SSD-70283710: 1 Crescent Street, Holroyd

Transport Impact Assessment - Response to Submissions

14 November 2025

REV.	DESCRIPTION	DRAWN	CHECK	APP'D	DATE
A	ISSUE FOR DISCUSSION	KR	SR	SR	21/11/24

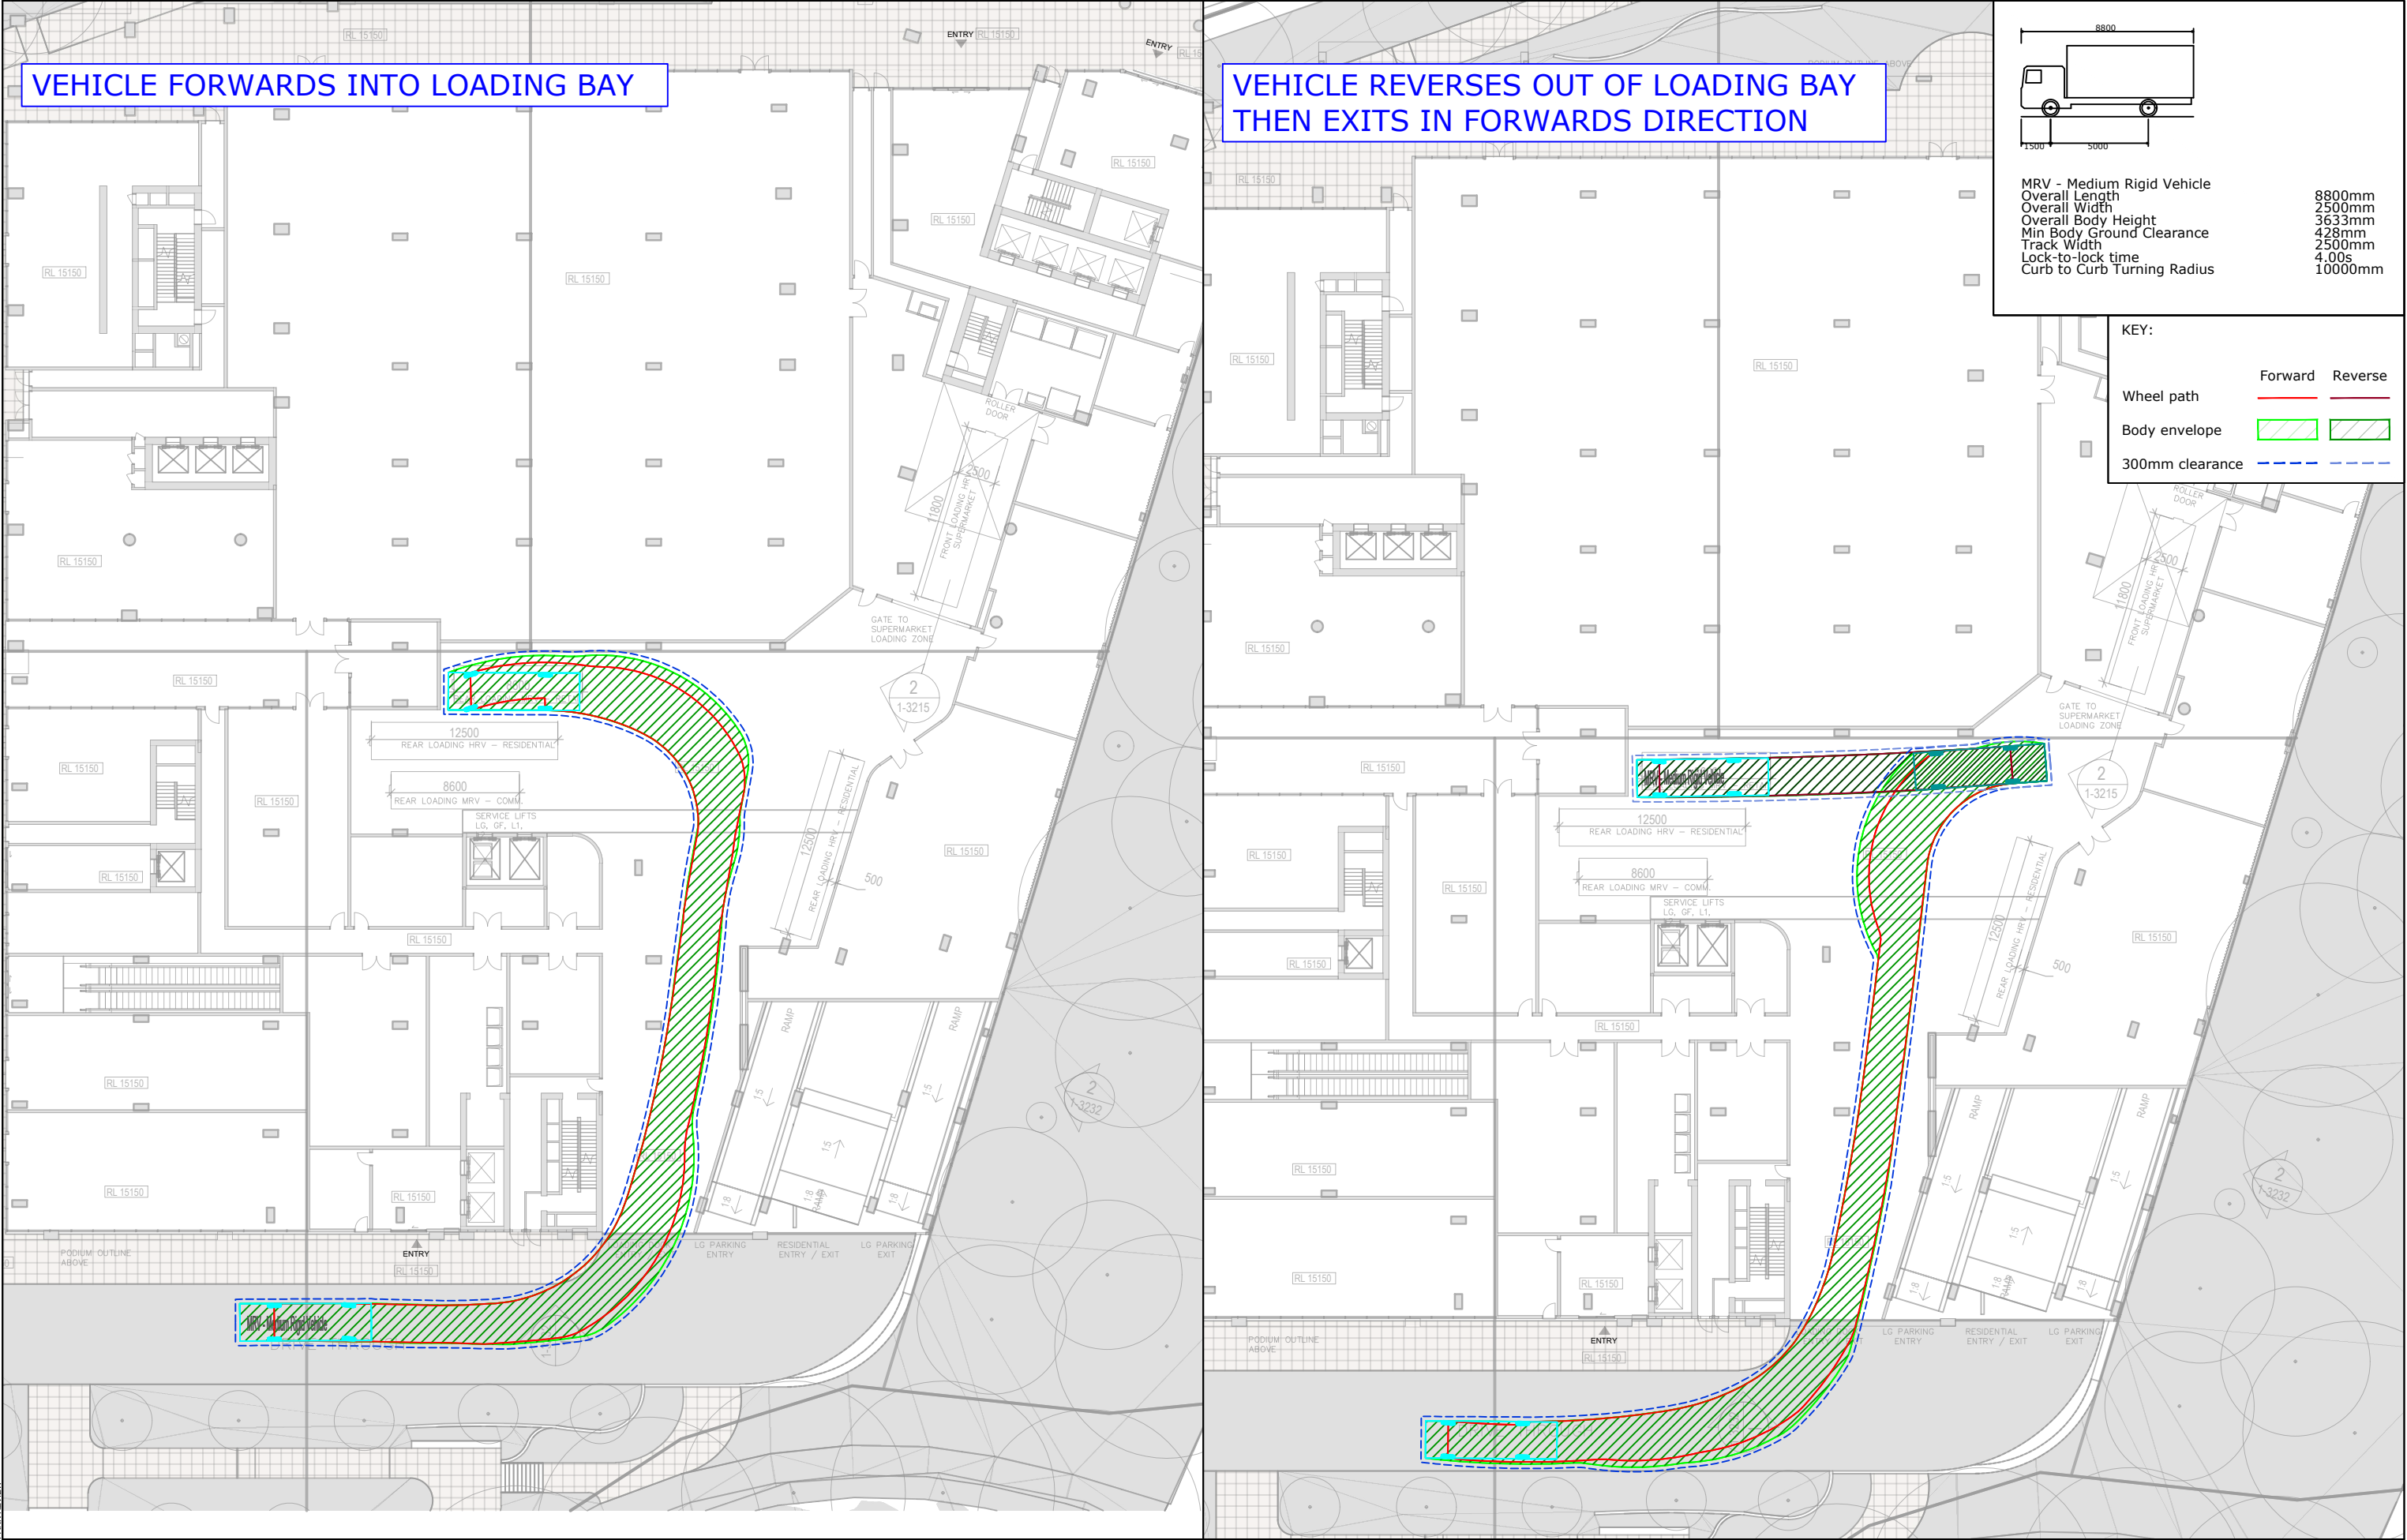
CC-9	Loading bays The 'general loading dock' appears to be deficient in area and detail to accommodate parking, loading and manoeuvring requirements for trucks required for the 2,500m ² of retail space and 5,000m ² of non-retail commercial space. If the general area is utilised by a number of trucks and a further truck then arrives in a forward direction, there appears to be deficient space for that truck to either turn and exit or enter a waiting phase while other truck/s manoeuvre out of the area (if at all possible). Creating a logjam of delivery vehicles and possibly	Loading bay has been redesigned and includes a turntable to manage movement of vehicles.	Section 5.4

DPHI-B-12	Provide further consideration to the space, access and manoeuvrability within the Building 1/2/3 loading dock, in particular:	Loading dock has been redesigned to include a vehicle turntable to allow access for trucks.	Section 5
DPHI-B-12-A	a) it is not possible for HRVs to exit from the (N/S oriented) 'front loading supermarket' and 'rear loading residential' spaces when the (E/W oriented) 'rear loading residential' HRV space is occupied	Loading dock has been redesigned to include a vehicle turntable to allow access for trucks.	Section 5
DPHI-B-12-B	b) swept path analysis of a vehicle entering/exiting the (E/W oriented) 'rear loading residential' HRV space has not been provided	Loading dock has been redesigned to include a vehicle turntable to allow access for trucks.	Section 5
